Town & Country Planning Act 1990 (as amended)
Town and Country Planning (Development Management Procedure) (England) Order 2015
Application for Planning Permission

Development Change the use of 1/2 the site area to a hard standing storage area (resubmission following F/9/19/PL).

Location Land Adjacent Station Cottages Ford Road Ford

LOCATION PLAN
F/2/20/PL

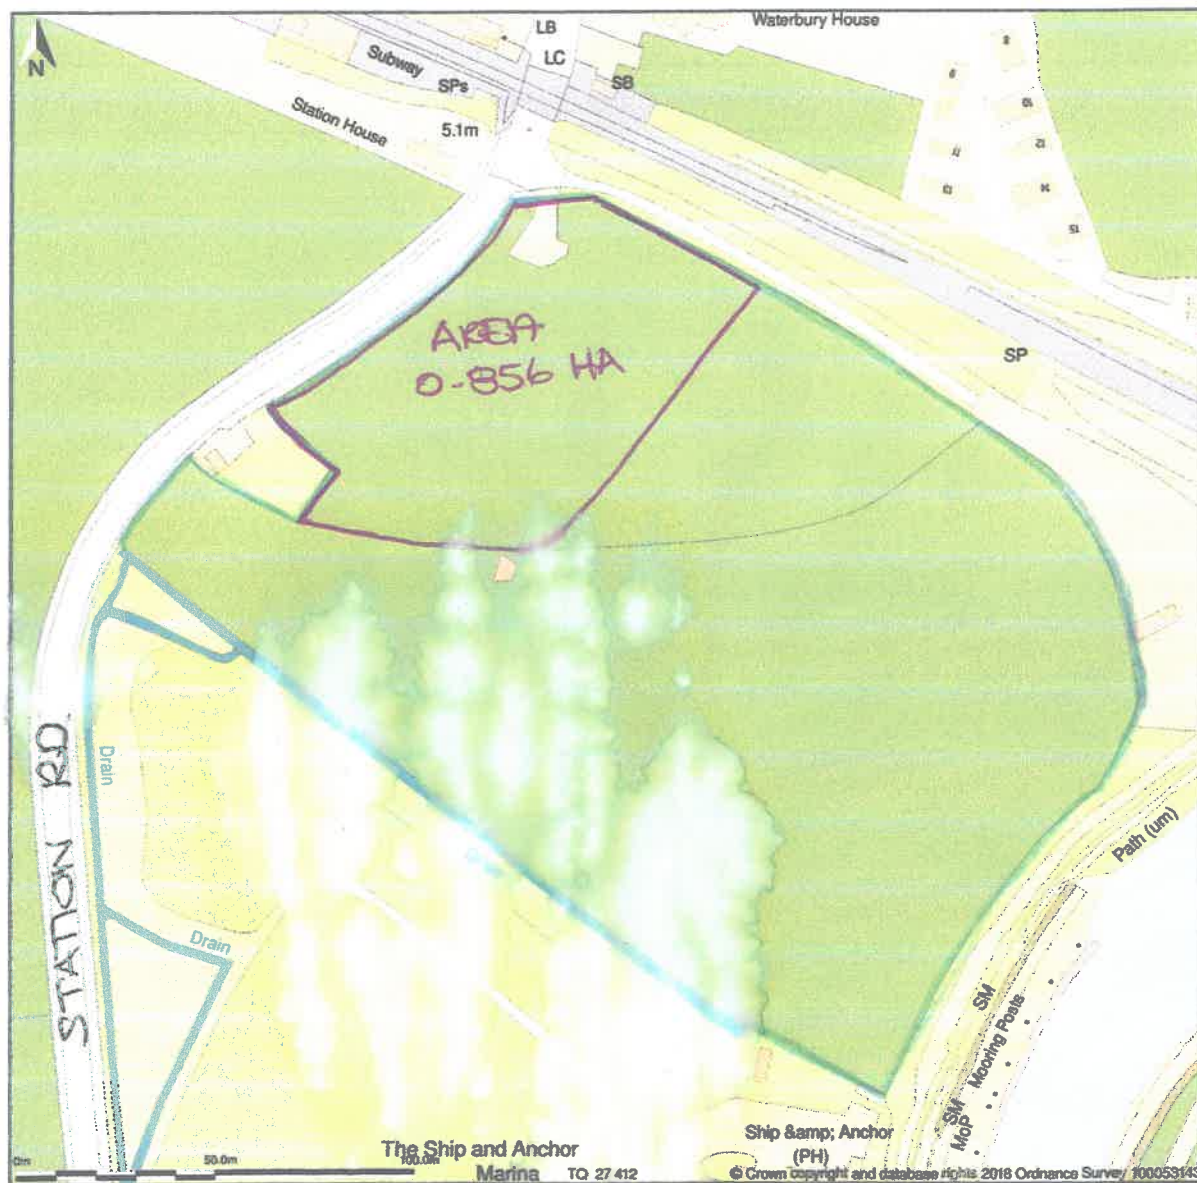
Location Plan Amend

Please only red edge the application site and blue edge any other land owned/in control of applicant and provide one named road. *enclosed*
